# 2026/01/27 Phase 1 Landscape constraints

MARKUP OF: Heathrow Car Park - Phase 1 plan

TITLE: PHASE 1 - LANDSCAPE PLAN

DRAWING NO: 0586-WSP-XX-XX-DR-L-1001 REV: P07

Drawing Title
PROPOSED SITE PLAN - PHASE 1

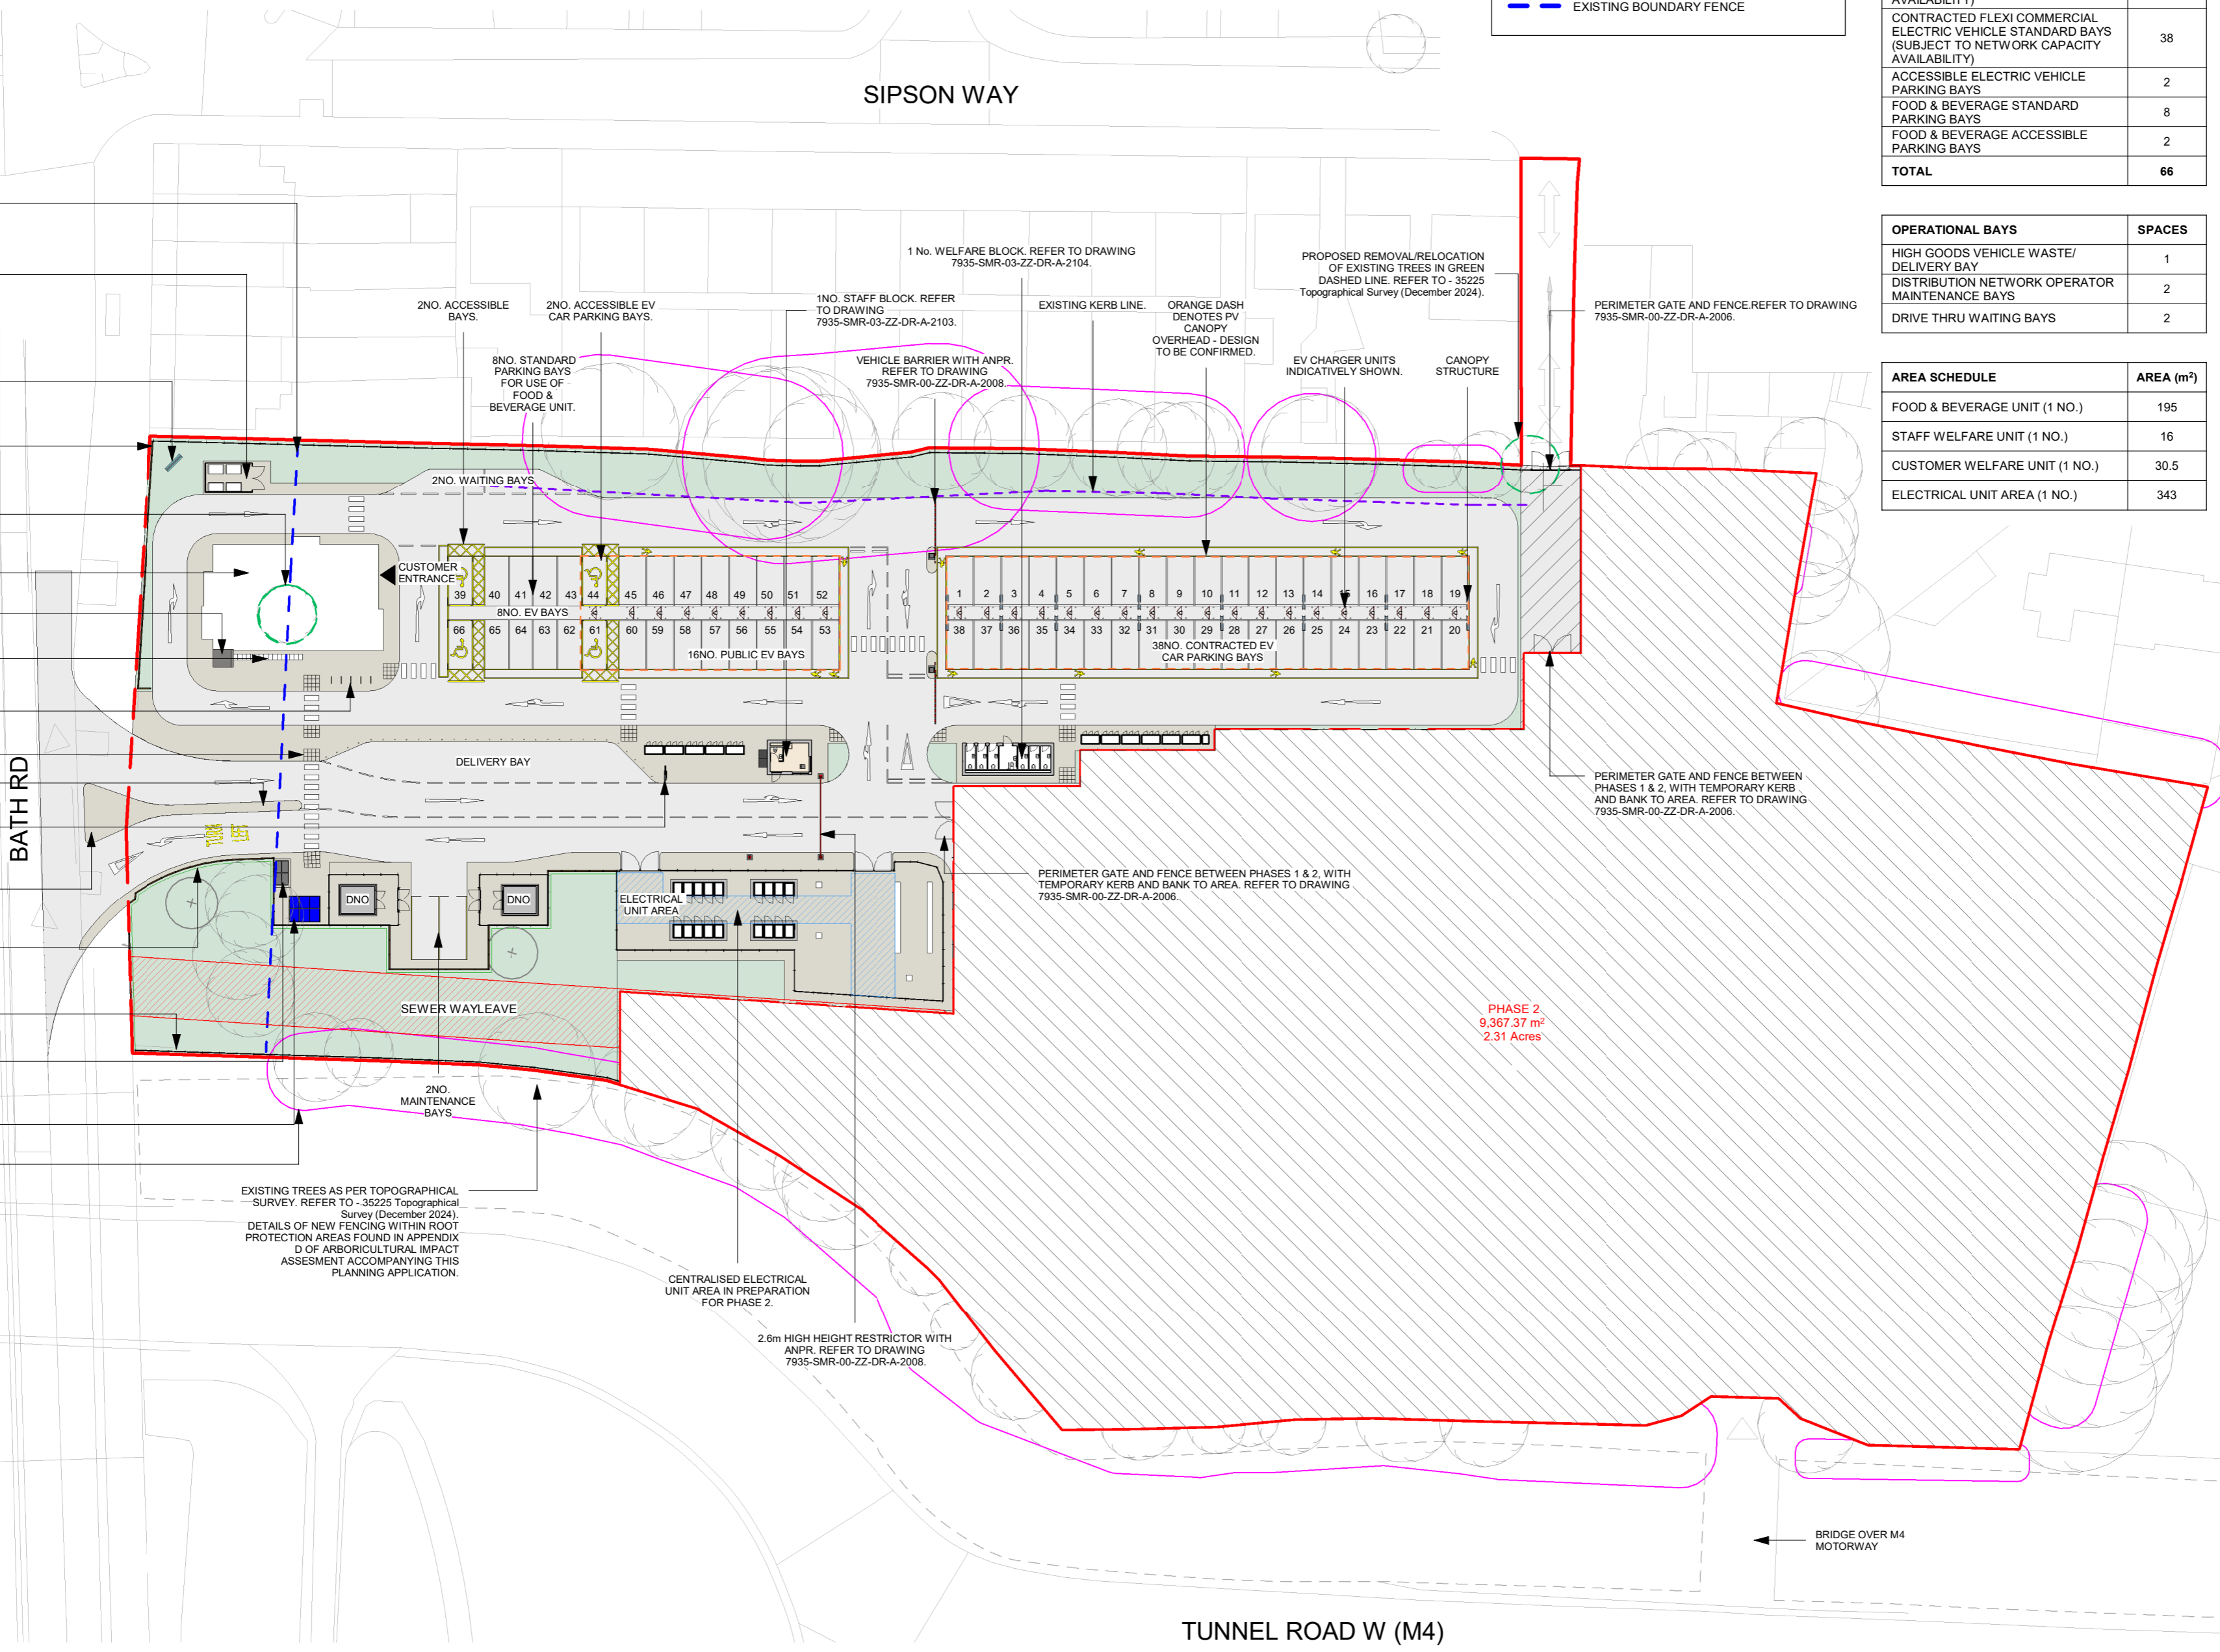
**Root Protection Area (RPA)**  
 No proposed tree planting within RPA (likelihood of damage to existing tree roots and difficulty of establishment of proposed tree).

Width of verge unsuitable for proposed tree planting

Width/proximity to easement unsuitable for proposed tree planting

SuDS tank and associated pipework (unable to plant trees here)

No proposed tree or shrub planting within Thames Water / sewer easement

**Root Protection Area (RPA)**  
 No proposed tree planting within RPA.  
 Refer to legend and plan for location of RPAs.  
 Refer to Arboricultural Impact Assessment (AIA) 2024UK337123-ARB-AIA-001 for further details.
